The Secretary
NSW Department of Planning, Industry & Environment

15 July 2022

I refer to the Department's email of 12 July 2022 regarding the exhibition of the Environmental Impact Statement (EIS), for State Significant Development SSD-11606719 Eastern Creek Recycling Ecology Park Throughput Increase for 'Environmental Impact Statement (EIS) for Eastern Creek Recycling Ecology Park Throughput Increase. Increase in throughput of an existing Recycling Ecology Park from 2 million tonnes of waste per annum (tpa) to 2.95 million tpa, including upgrade of supporting site infrastructure' at 1 Kangaroo Avenue, Eastern Creek (Lots 1-2 DP 1145808, Lot 2 DP 1247691, Lot 7 DP 1200048) in the Blacktown City Council Local Government Area (LGA). Submissions need to be made to the Department by 10 August 2022.

PRELIMINARY

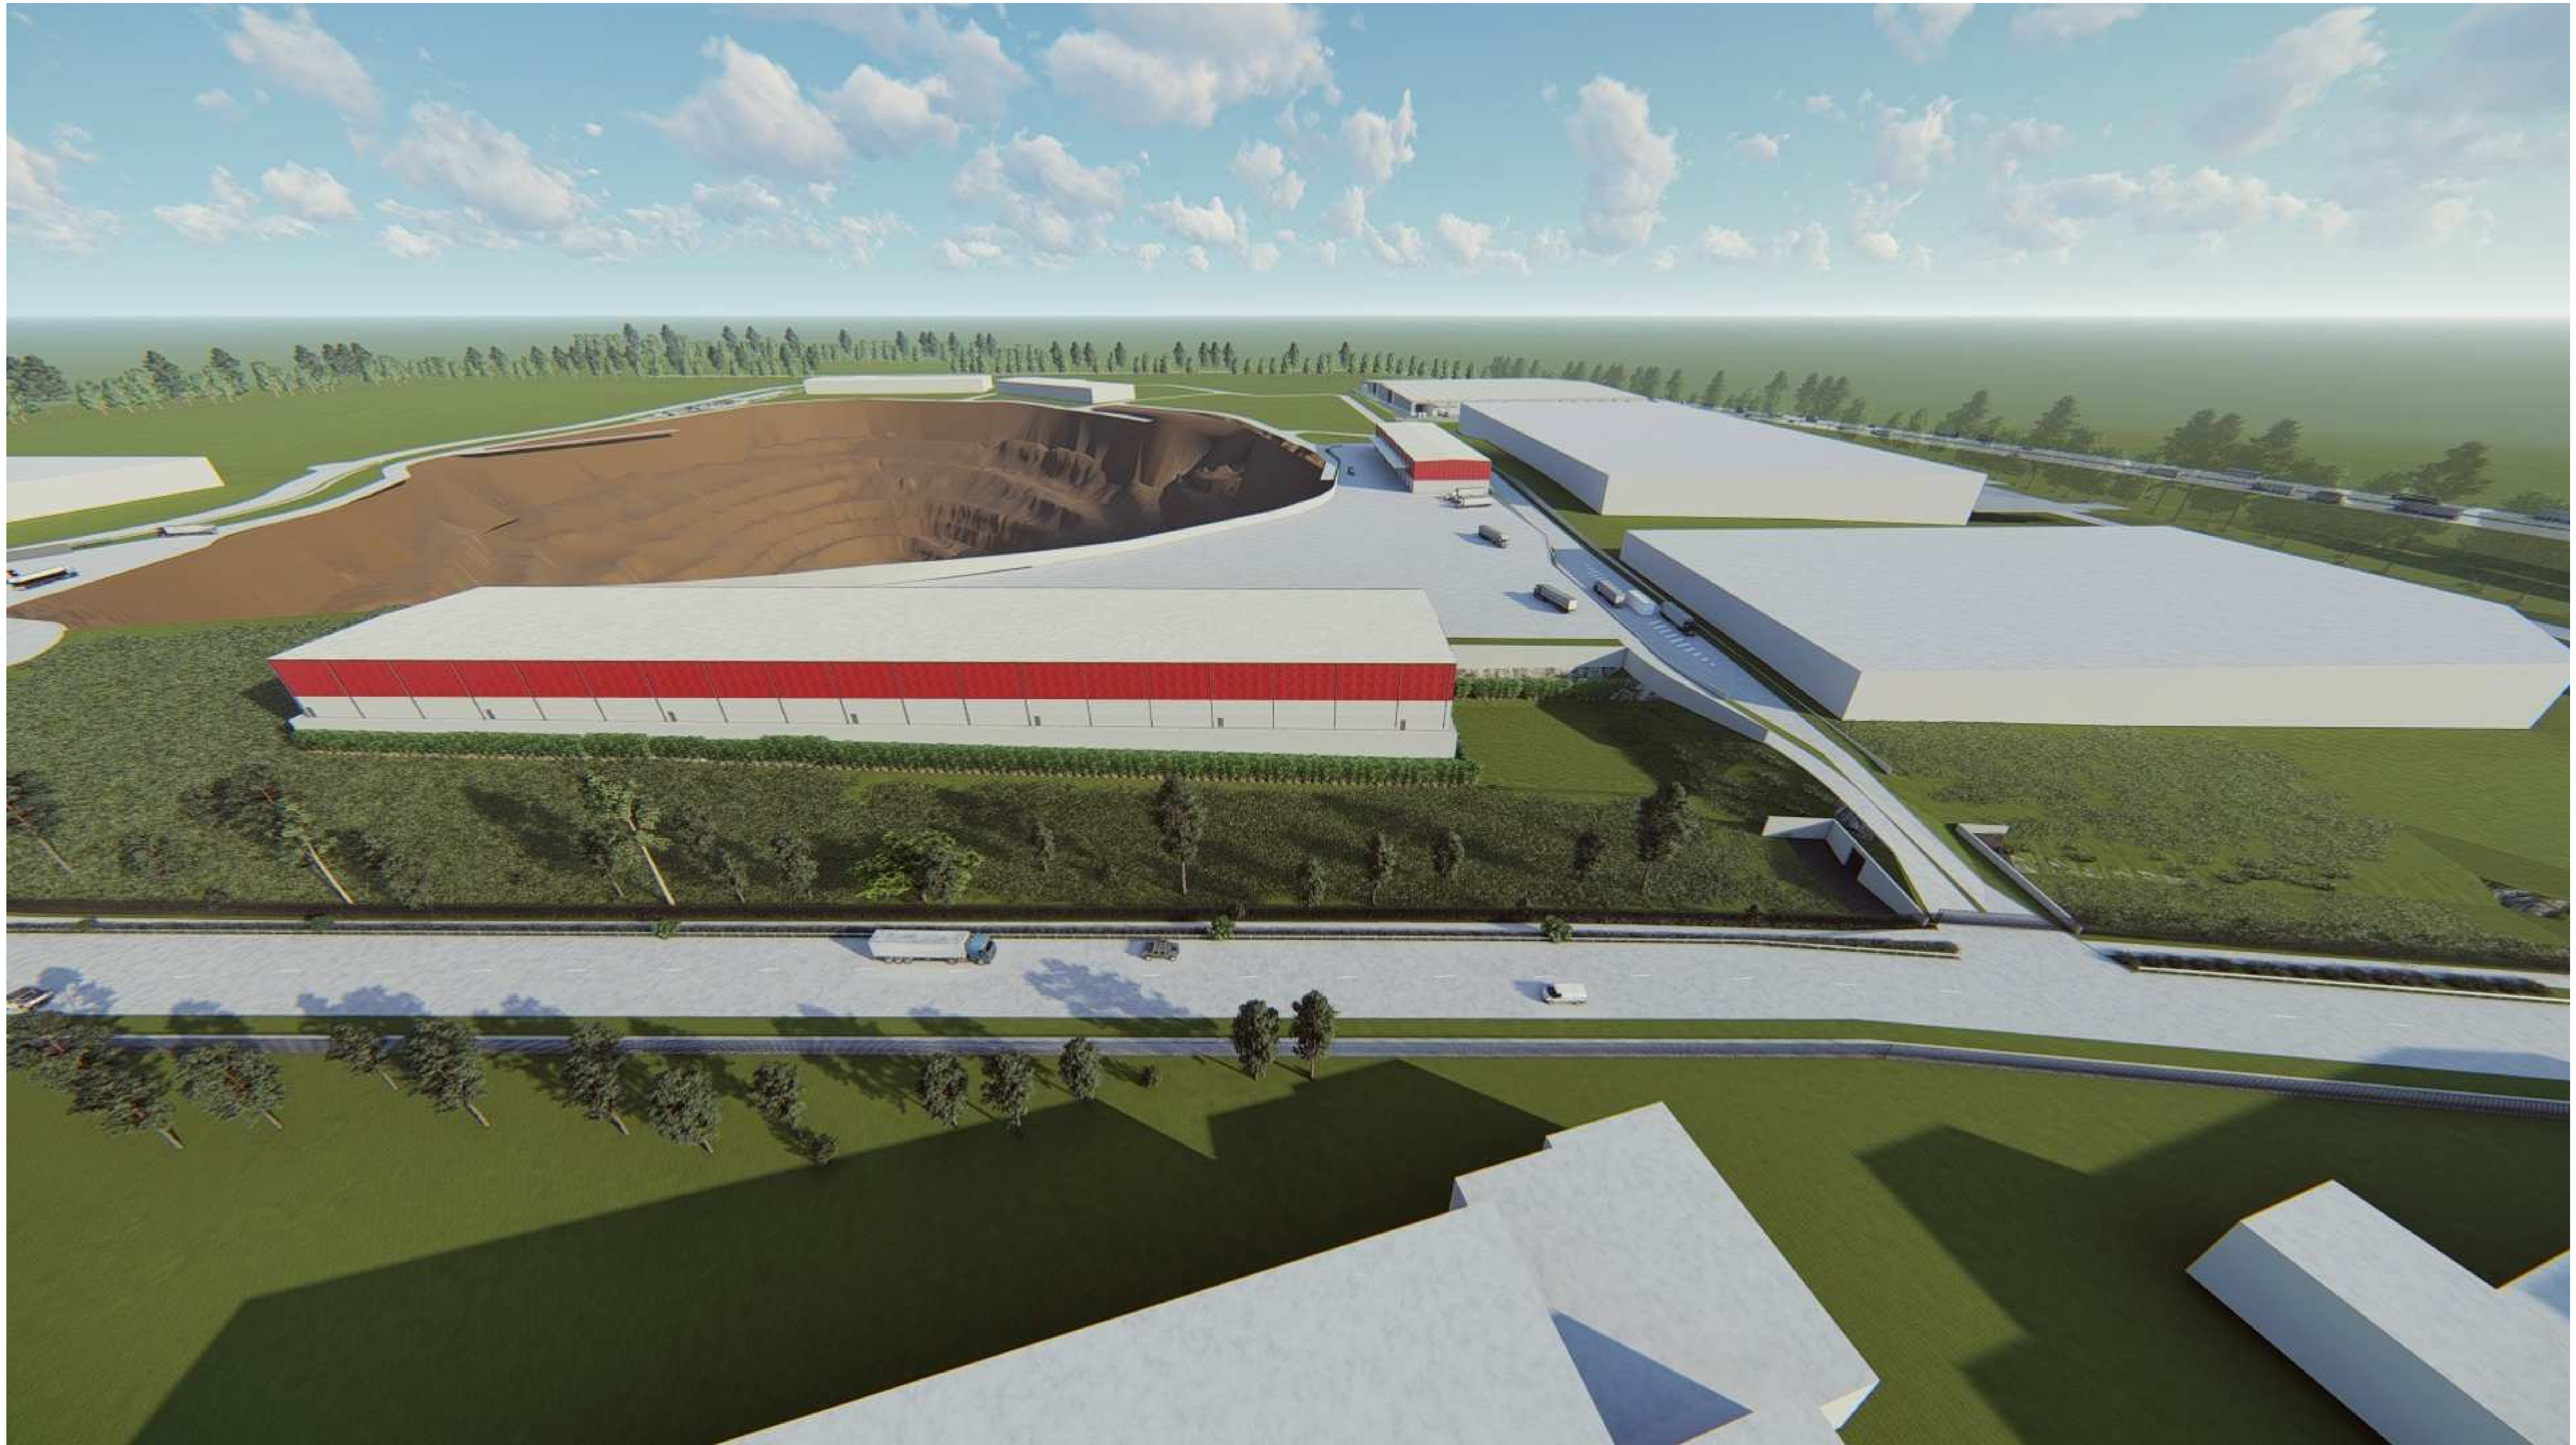
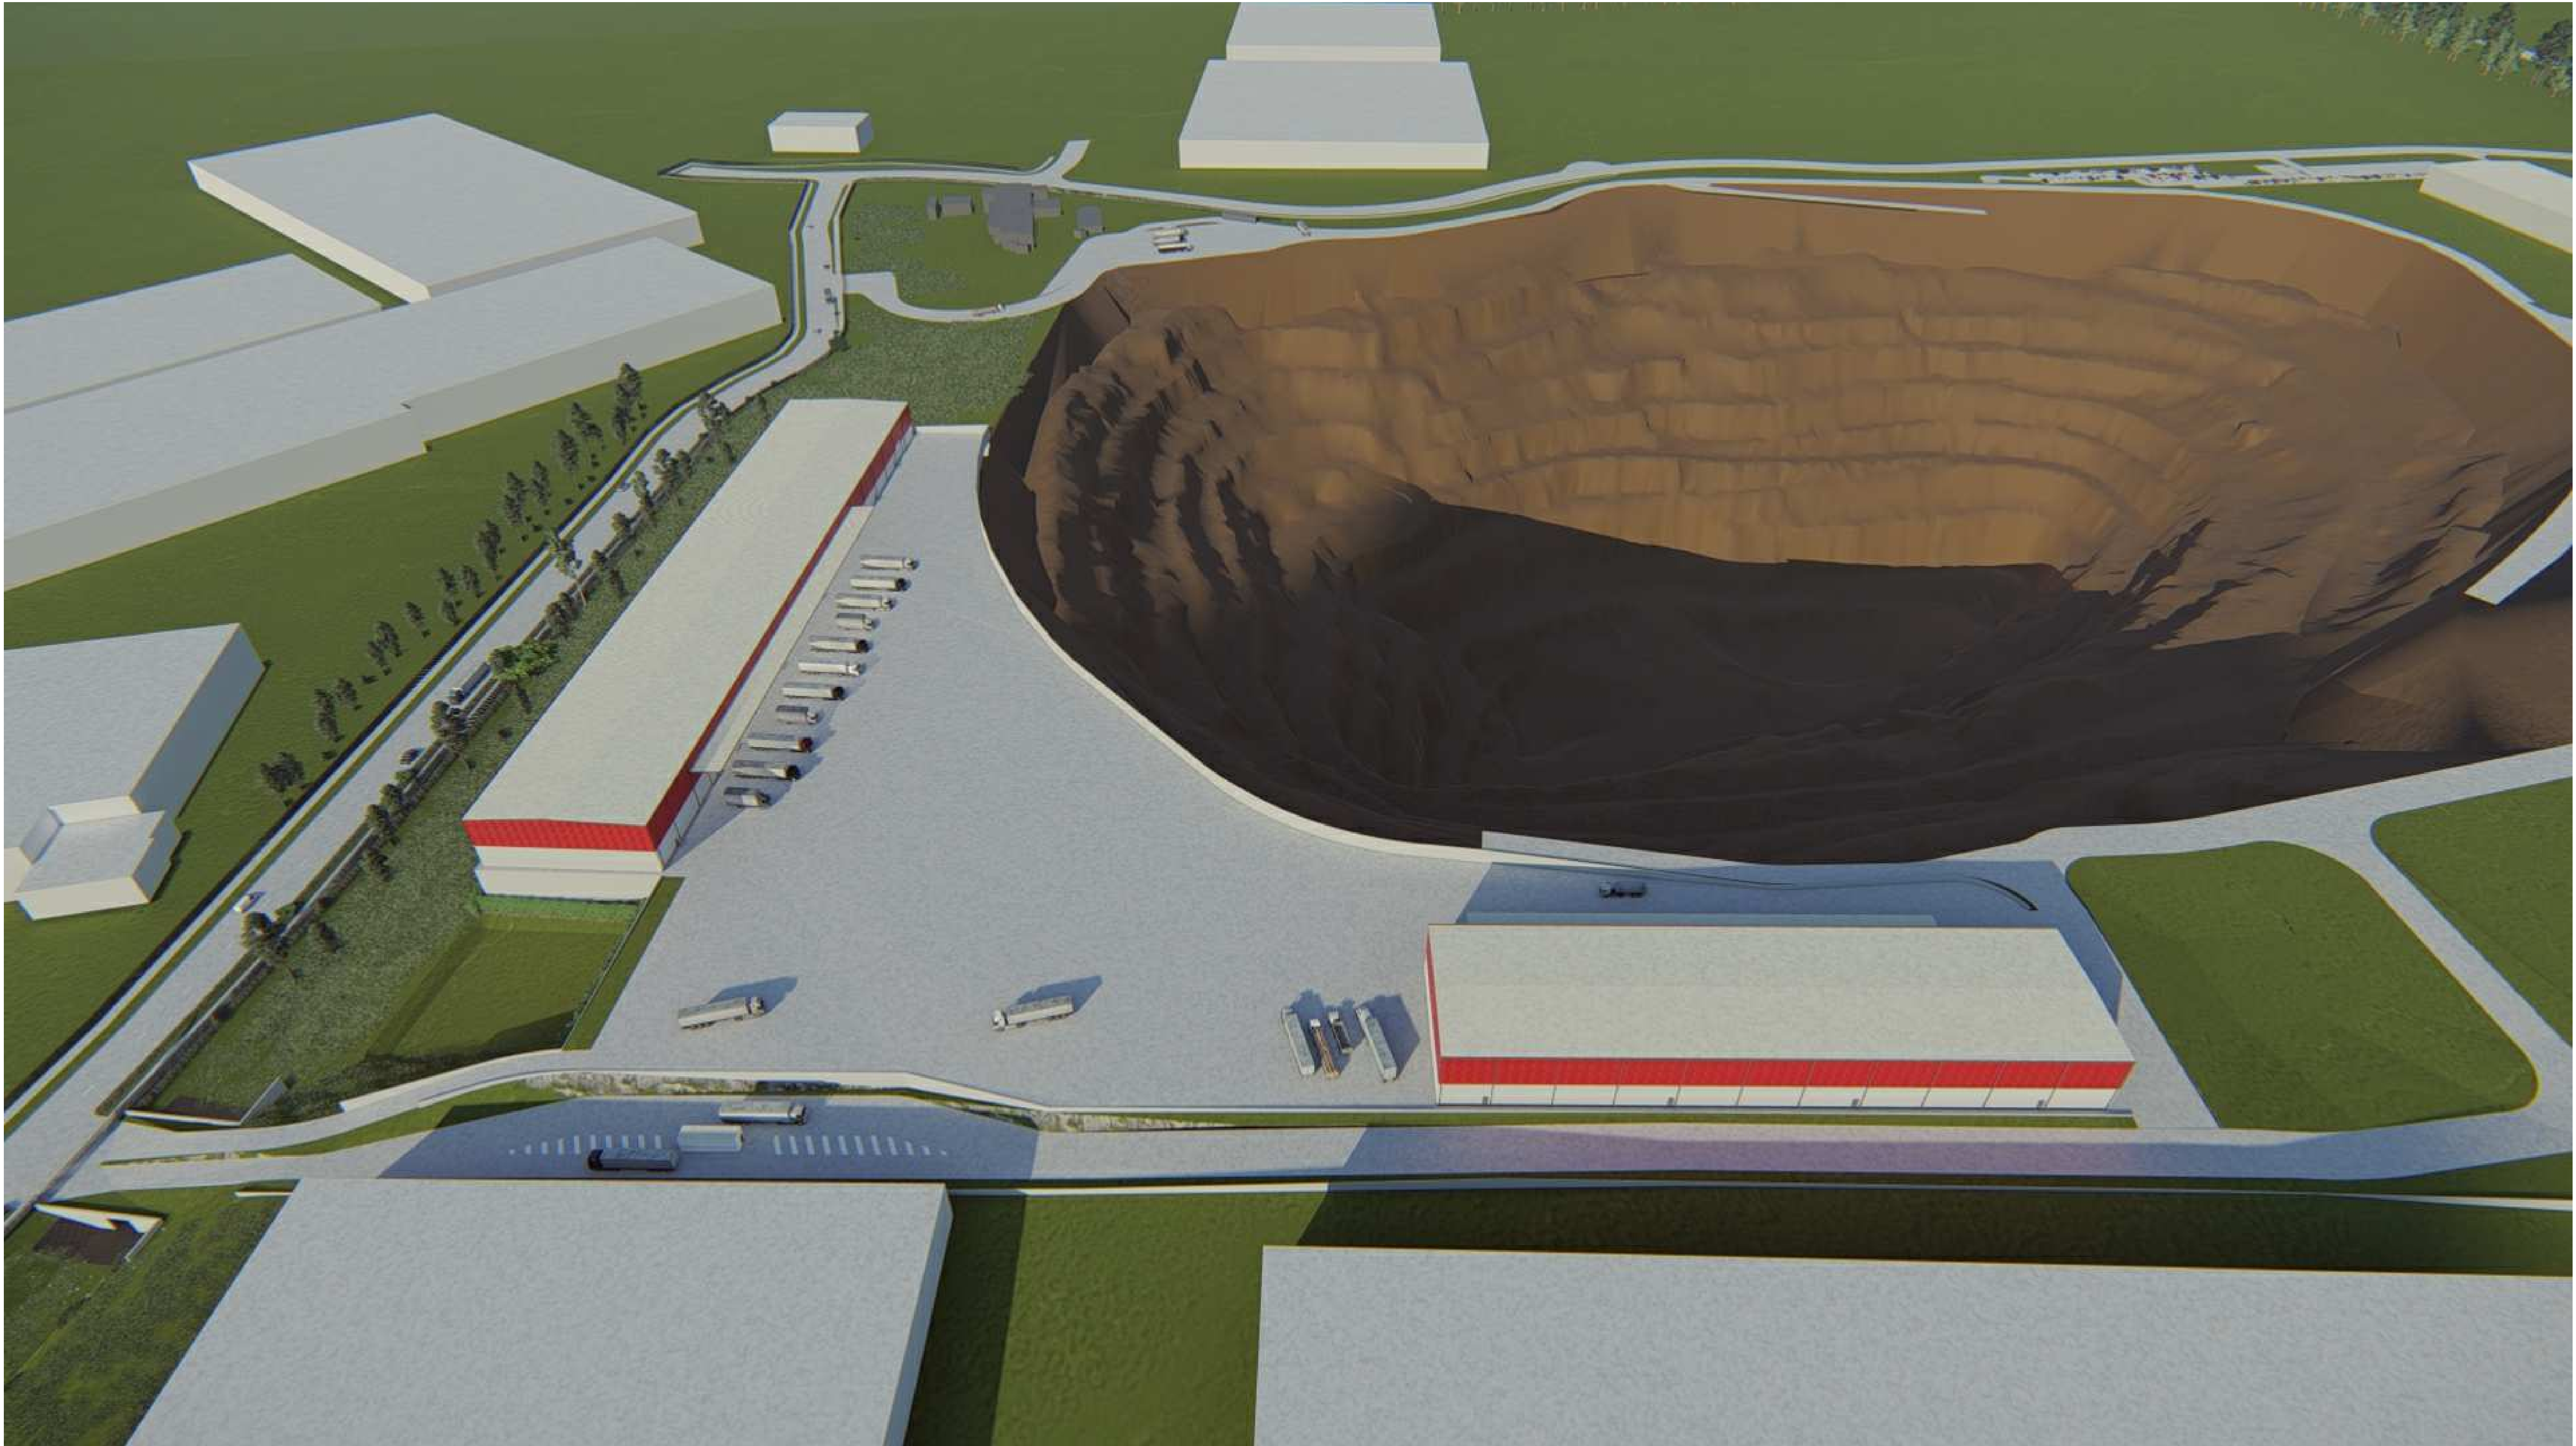
The electrical substations do not appear to be shown in the Architectural Drawings or the Project Visualisations. Any required padmount substation/s will need to be located within the property (in a suitable and accessible location) and be protected (including any associated cabling) by an easement and associated restrictions benefiting and gifted to Endeavour Energy. Please refer to Endeavour Energy's Mains Design Instruction MDI 0044 'Easements and Property Tenure Rights'.

Generally it is the Level 3 Accredited Service Provider's (ASP) responsibility (engaged by the developer) to make sure substation location and design complies with Endeavour Energy's standards the suitability of access, safety clearances, fire ratings, flooding etc.
